Our Reference: SYD20/01146/02

Departments Reference: SSD-9794683

EXHIBITION OF EIS - OAKDALE WEST ESTATE STAGE 3 - WAREHOUSES 2A, 2C, 2D, 2E - 2 - 18 ALDINGTON ROAD, KEMPS CREEK

Attachment A

**Figure 8 | Originally Proposed Buildings 2C and 2D Layout denoting the shared driveway**

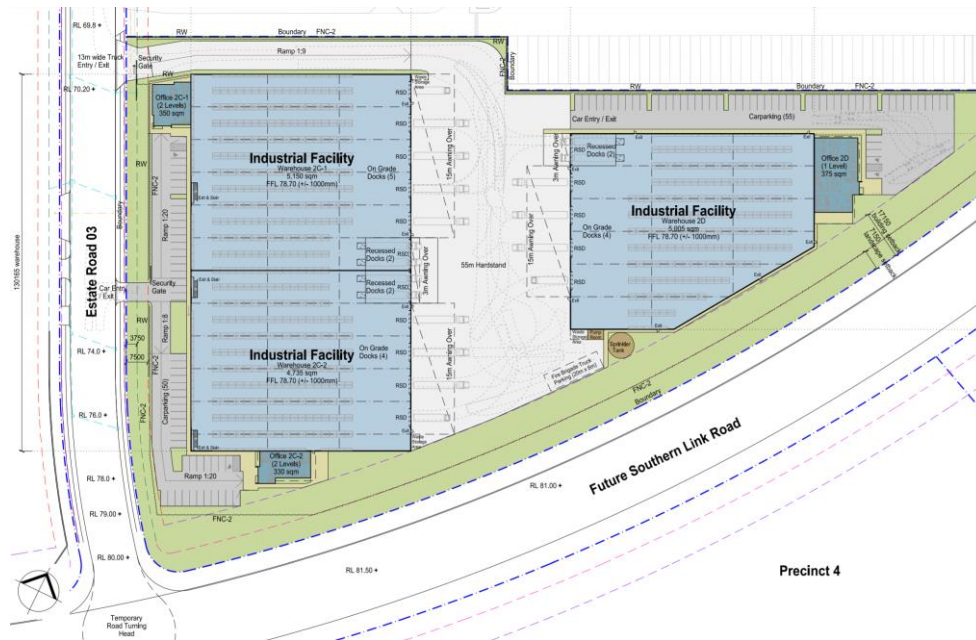
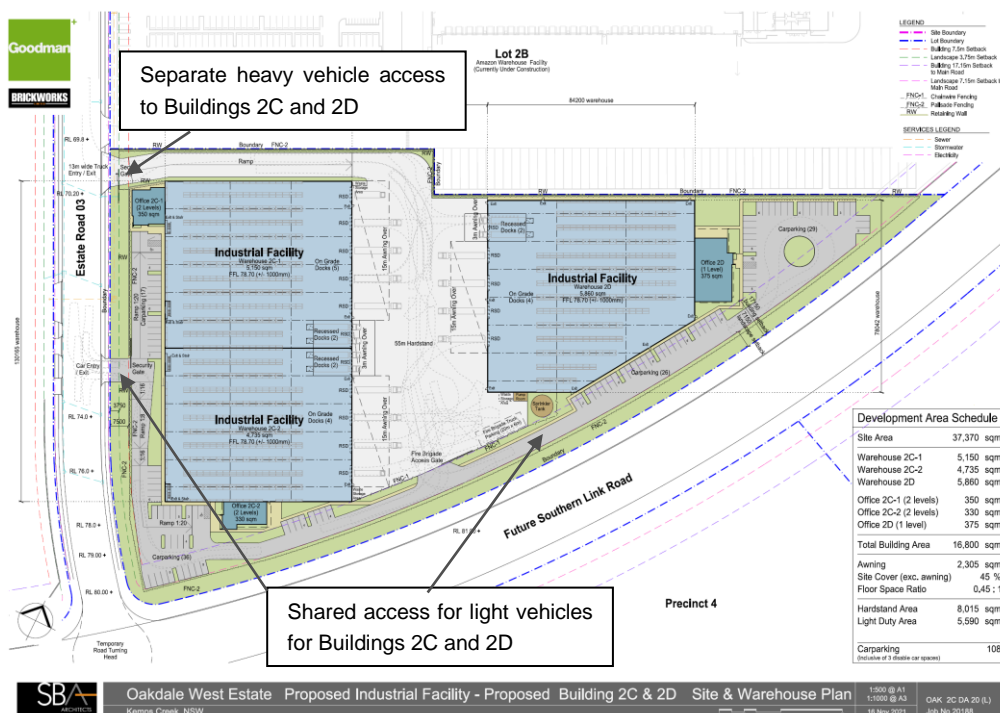
It is unclear from Figure 7 provided in the TA whether Building 2D parking area will be accessed by both heavy vehicles and cars via the same driveway, or separately.

The proponent should confirm whether there will be separate car/heavy vehicle access for Building 2D and provide justification if there is not. Sharing the access road will result in light vehicles mixing with a large amount of heavy vehicles.

The access for vehicular parking for building 2C is located in the centre of the development Lot (approximately 90m from the future SLR). Ideally the location of the vehicular access should be provided for away from intersections of major roads.

Relocate the access for vehicular parking for building 2C north away further from the intersection of SLR.
